**Response to Planning application from Hertfordshire County Council (T and CP GDP Order 2015)**

District ref: 6/2023/1433/COND  
HCC ref: WH/17534/2023  
HCC received: 17 August 2023  
Area manager: Manjinder Sehmi  
Case officer: Chris Carr

Salisbury Square Hatfield AL9 5AD

Submission of details pursuant of condition 2 (construction management plan) on planning permission 6/2021/3422/MAJ

Drawing No
221111-CON-XX-00-DR-C-6000

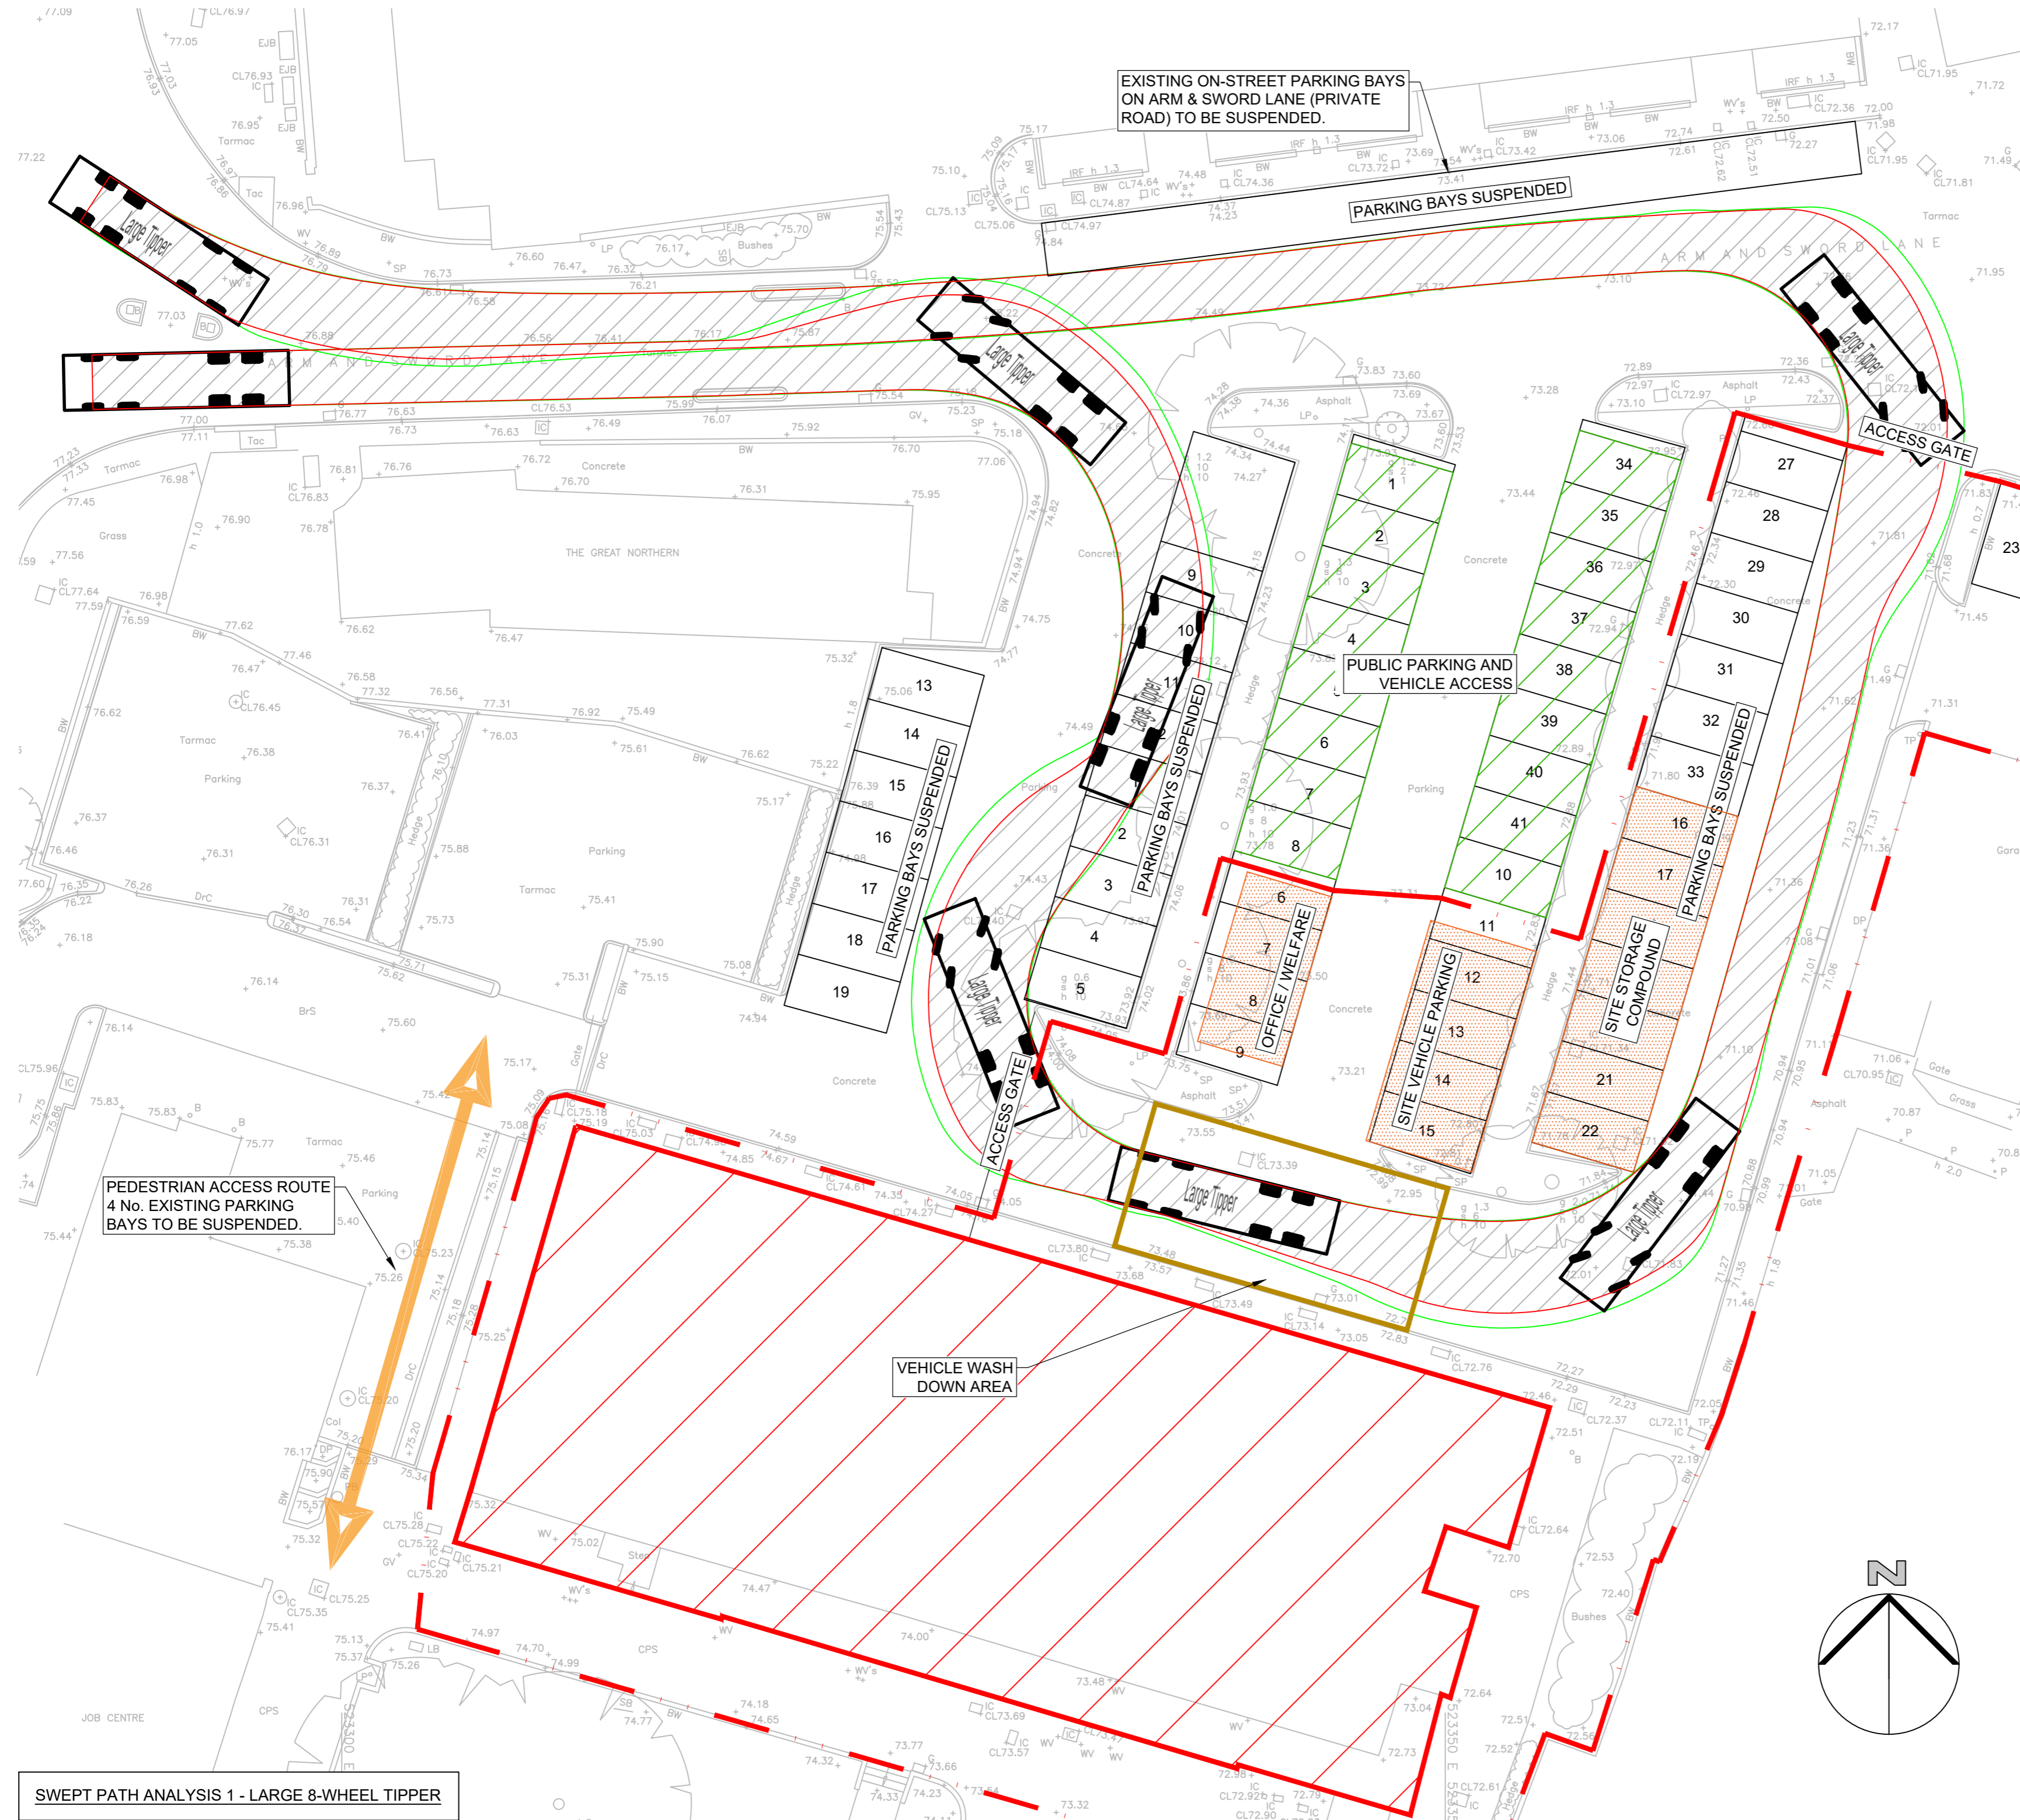
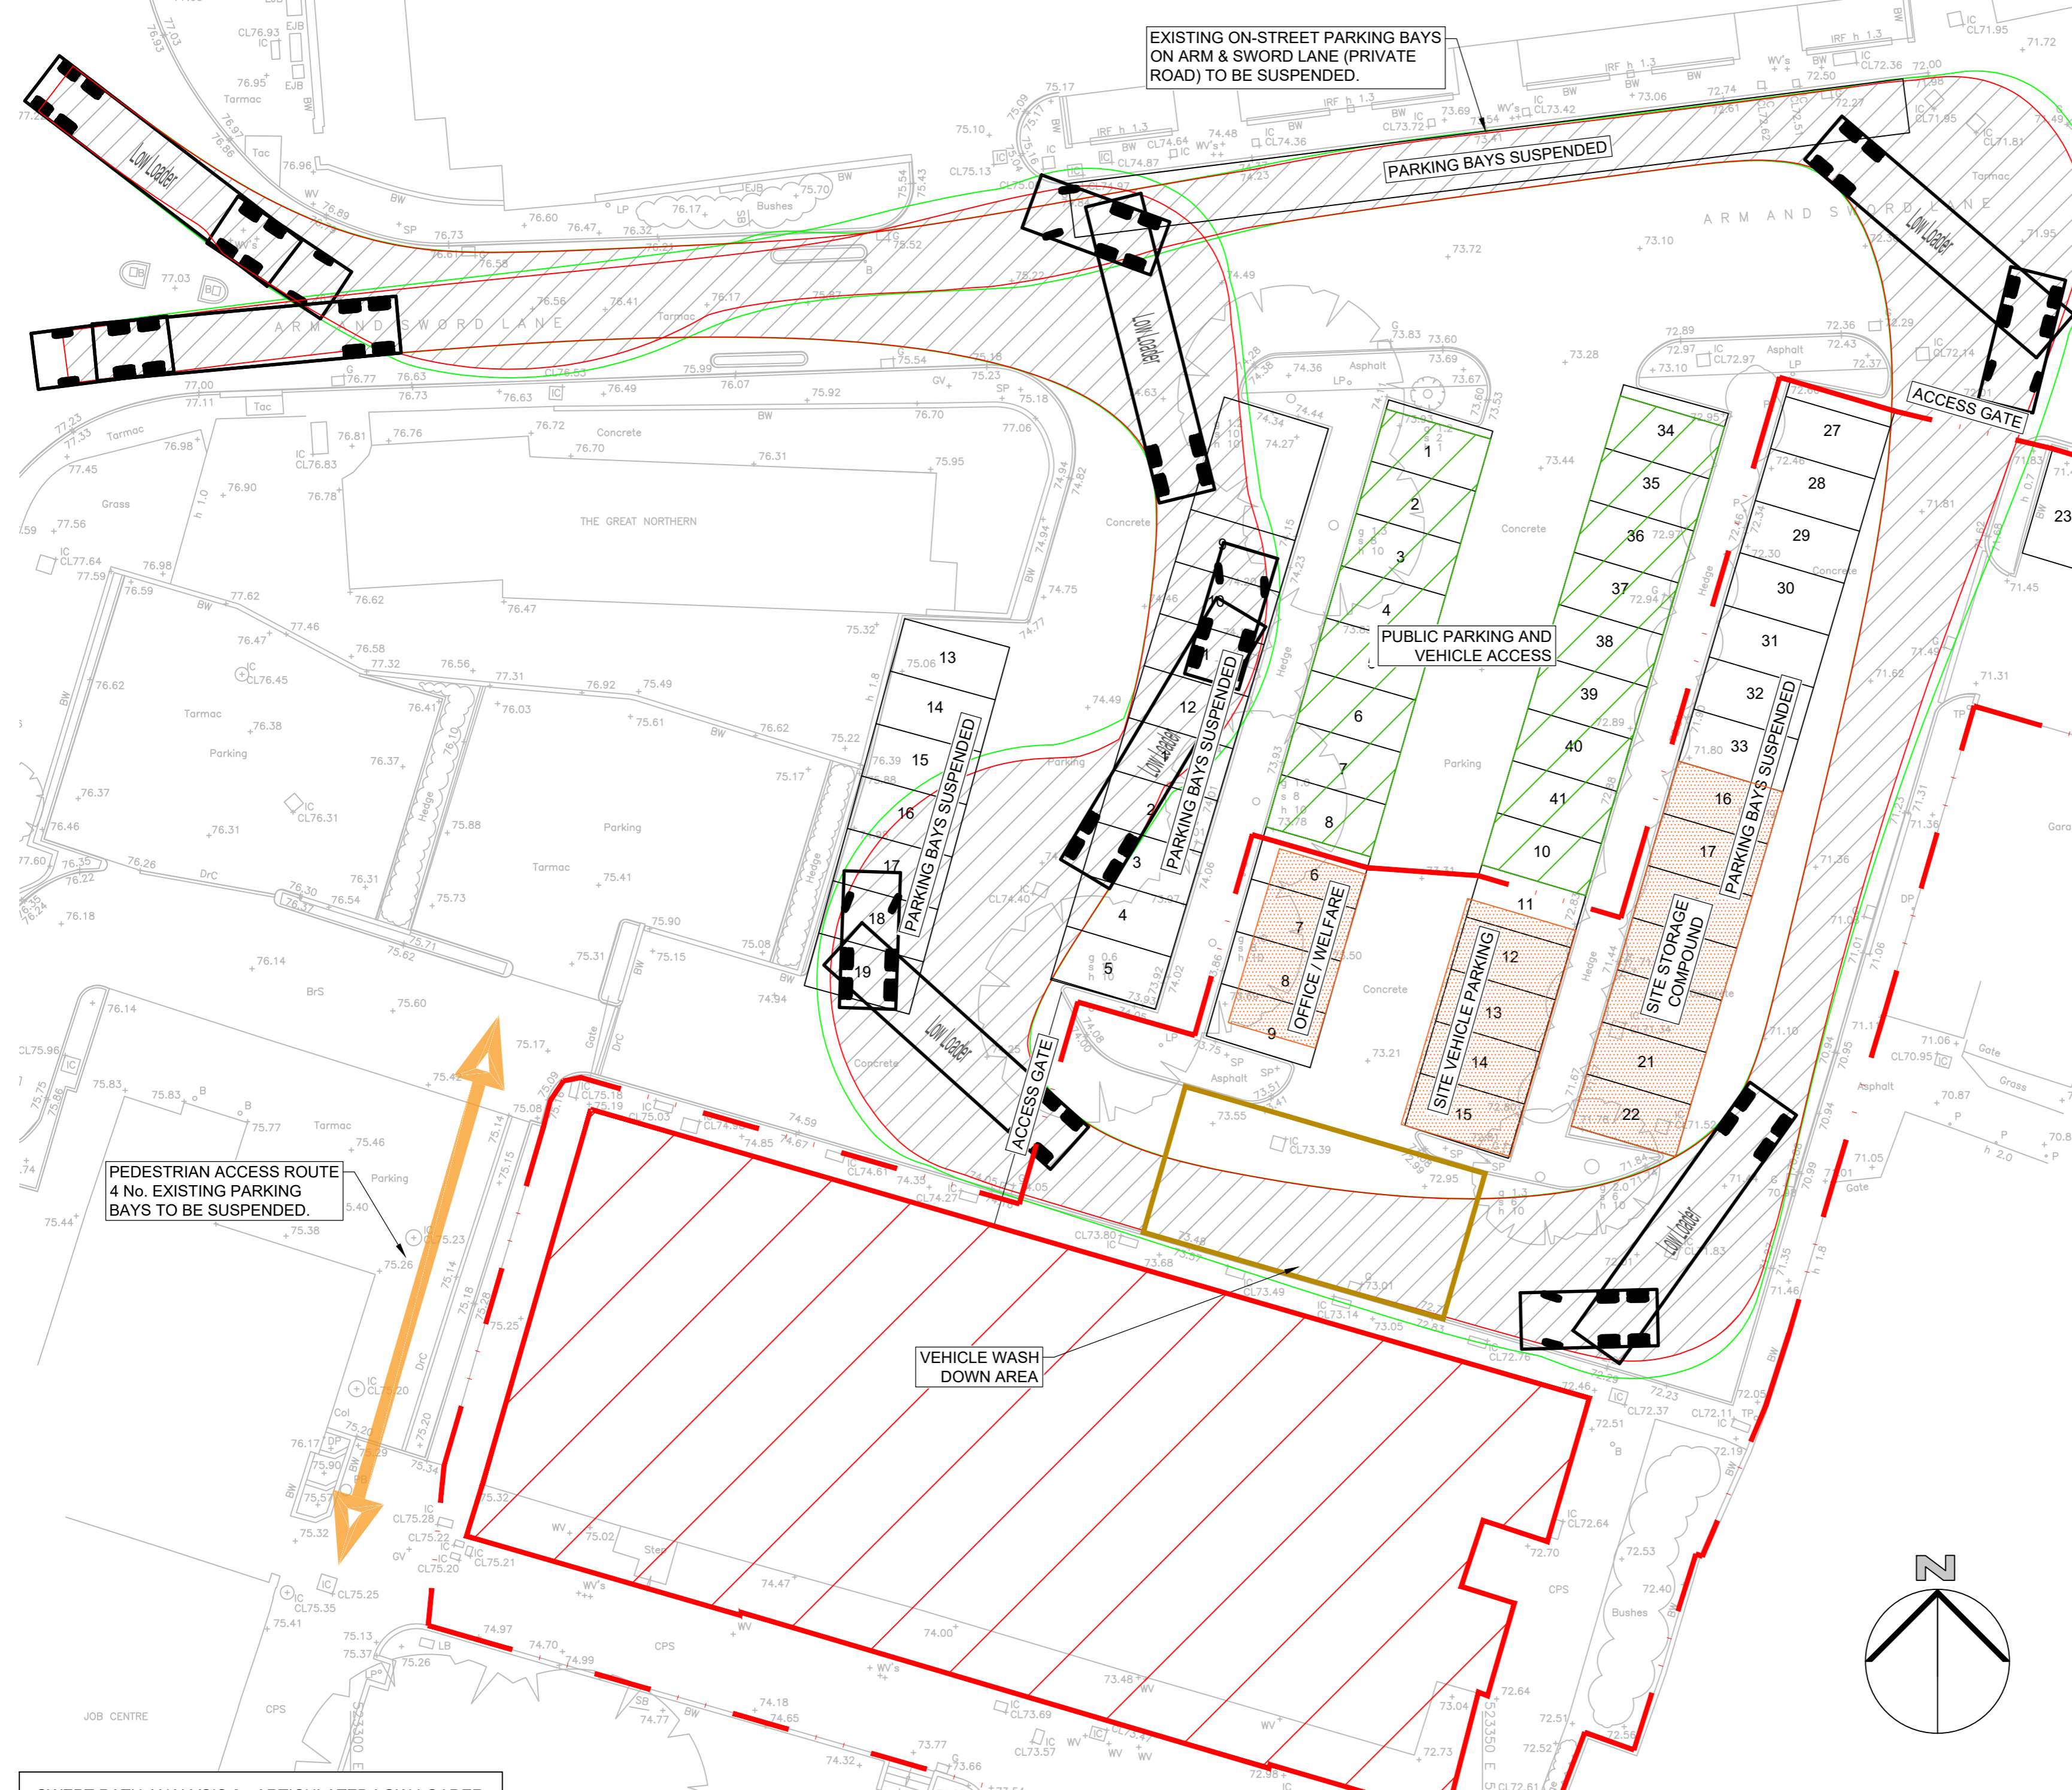
a) In HCC initial response it was identified that the swept path assessment for both vehicle types, long low loader and a large tipper, overran on-street parking bays and these bays need to be identified as temporarily suspended which is the intention during the construction phase. The applicant has submitted a revised swept path analysis (same drawing referenced 22111-CON-XX-00-DR-C-6000-P02) The plan now shows bays being marked as temporarily suspended. This is considered acceptable.

Conclusion: Condition 2 (part a) can be discharged.

Project	Date	JUN 2023
SALISBURY SQUARE OLD HATFIELD	Scale	1:200@A1
	Drawn	JT
Title	Engineer	AM
SITE ESTABLISHMENT DIAGRAM CONSTRUCTION PHASE	Project No	221111
Drawing No	Revision	
221111-CON-XX-00-DR-C-6001	P01

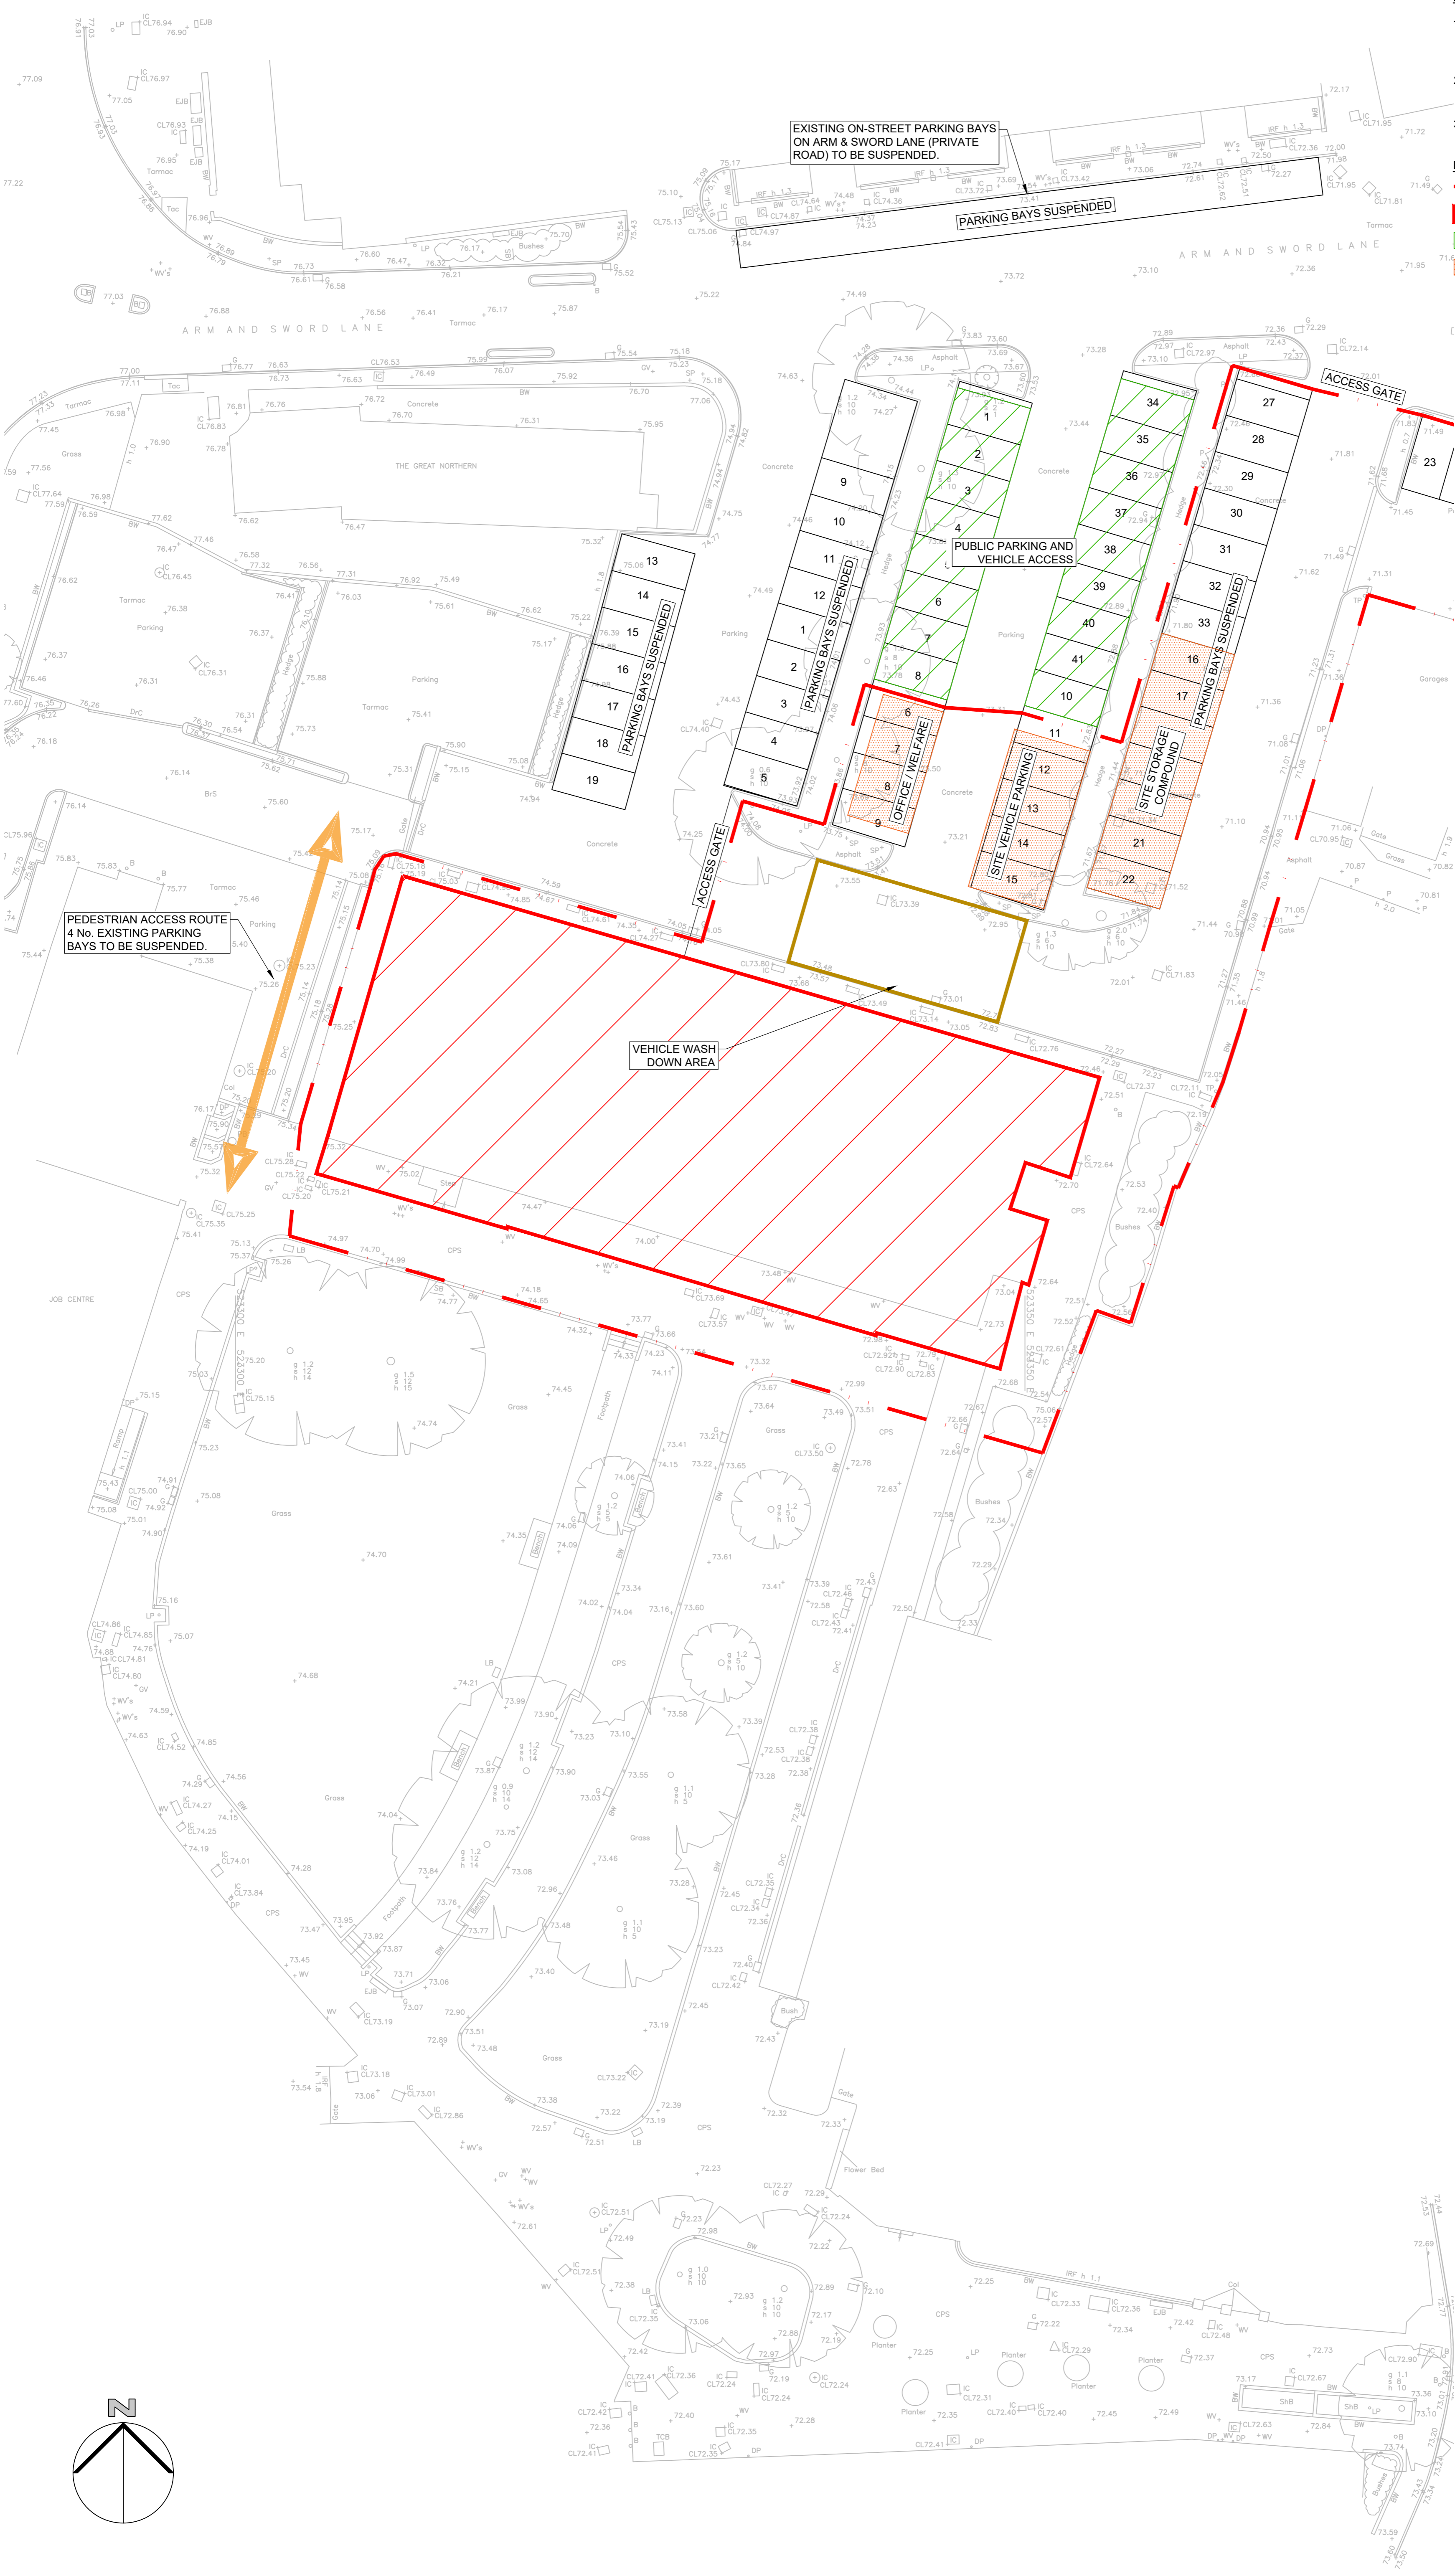
d) In the LHAs previous response it was requested that detailed on the proposed construction and storage compound is presented in drawing. The applicant has now submitted drawing number 22111-CON-XX-00-DR-C-6001 which includes details of the proposed site set up, provision of storage / access arrangements for pedestrians & vehicles / temporary accommodation units / wheel washing facilities/phasing and parking area. This has now satisfied this part of the condition.

Conclusion: Condition 2 (part d) can be discharged.
